Diane Sarkies - Submission re Application No.: SSI-5414

Application # SSI-5414

My husband and I support the proposed concept but we have a few concerns in regard to some parts of the proposal at Showground Station worksite precinct.

Figure 5 Hills Centre station – heavy vehicle routes

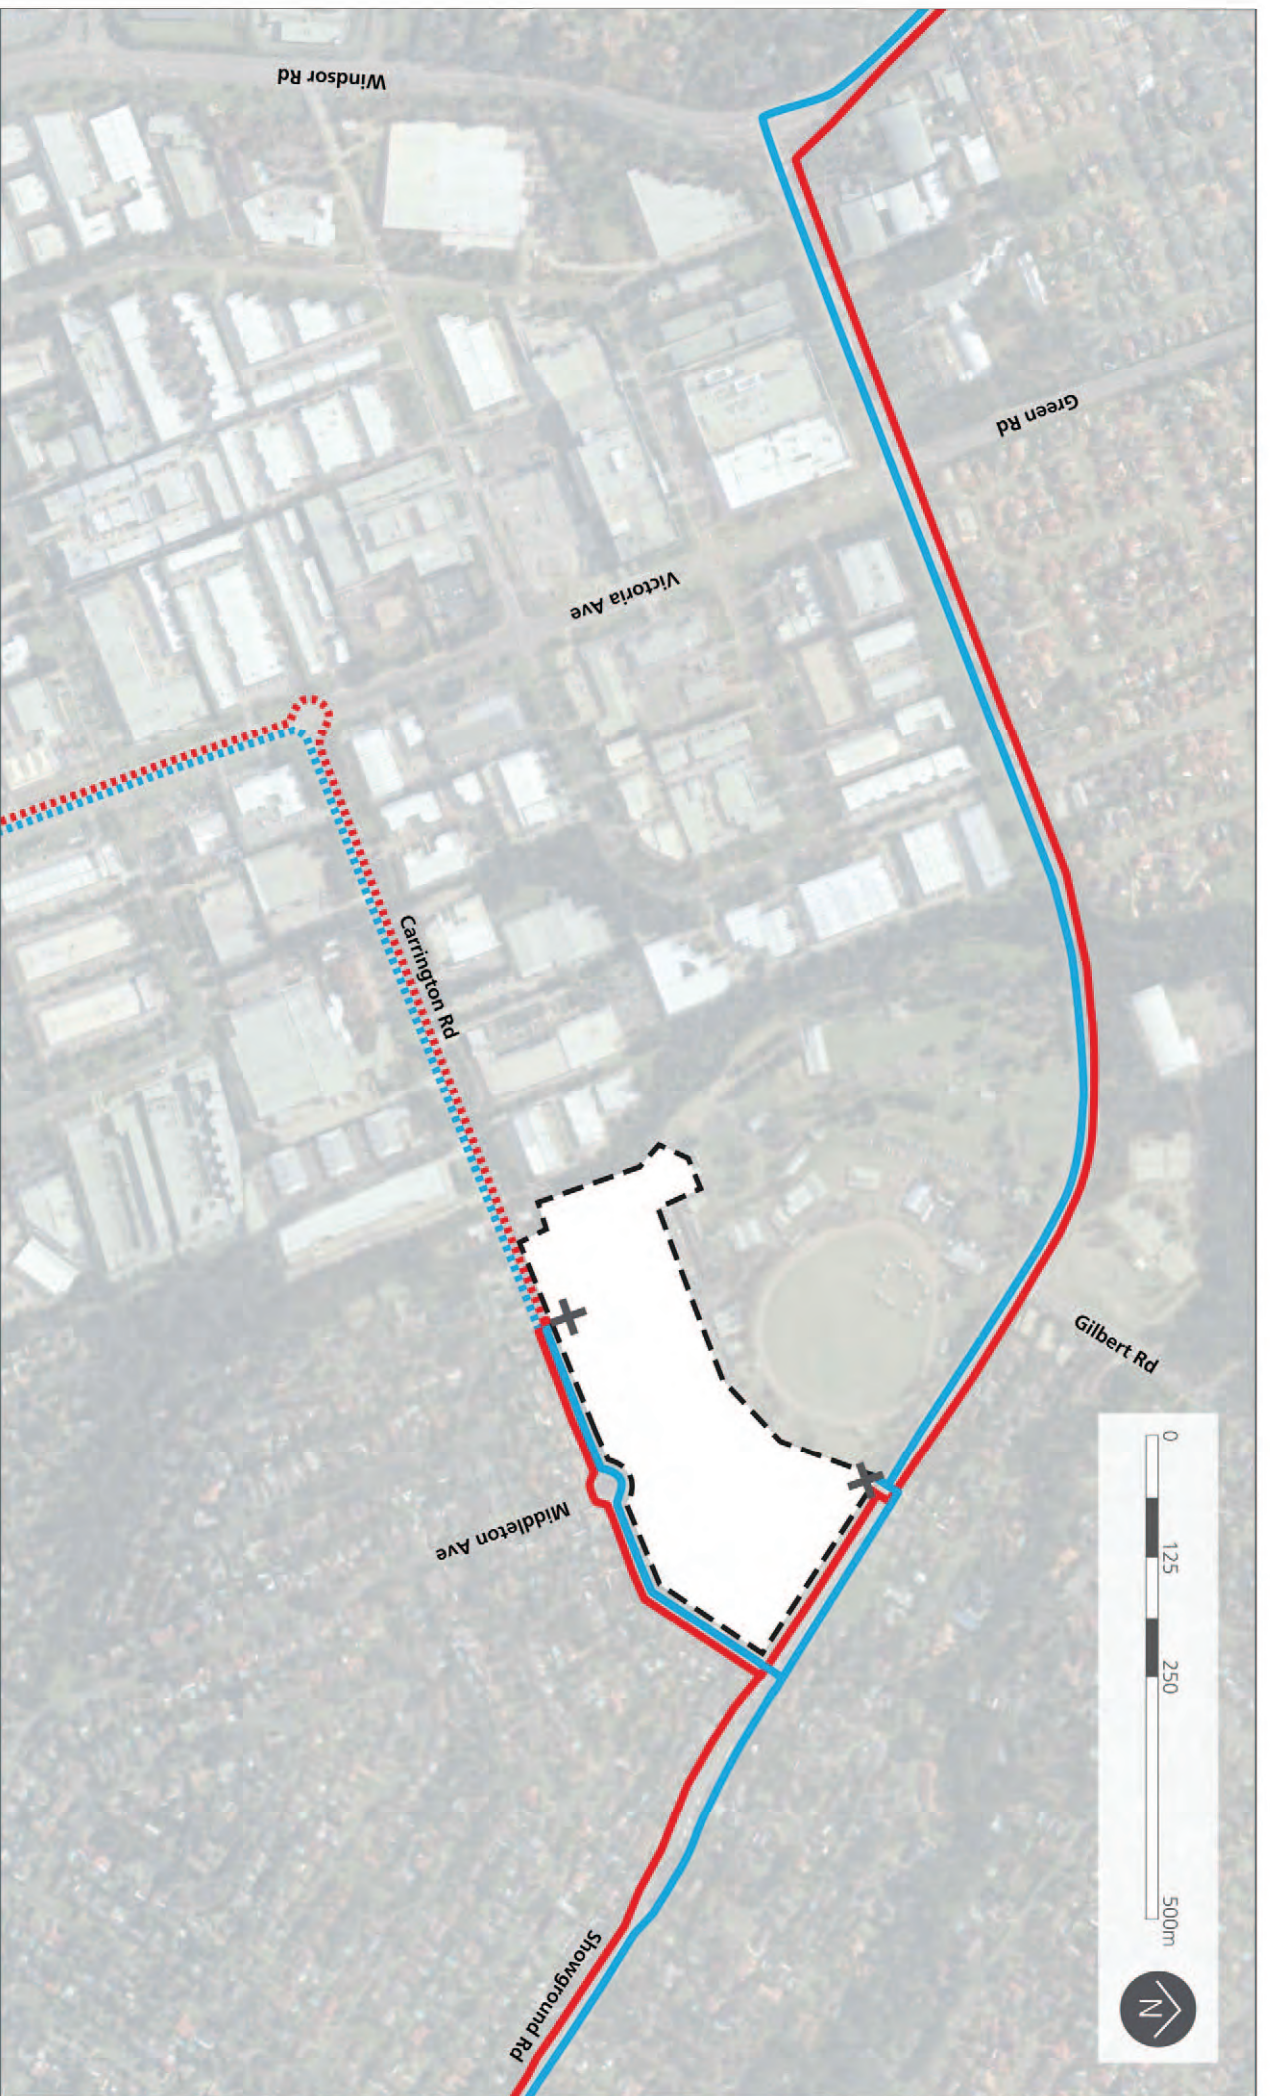
The site night-time truck noise is a concern as at present we are only disturbed on a regular basis by a weekly waste pickup from the Hills Centre and an irregular basis by showground carnival workers arriving and leaving at showtime and with the occasional circus. At present we are not affected by truck noise on Showground Road at any time of the night.

From your proposed access/egress using Carrington Road 24x7, our sleeping would be severely impacted. If trucks have to use Carrington Road at night-time maybe a left turn in and a right turn out could be implemented sending trucks through industrial area where the impact on residents sleeping could be downgraded.
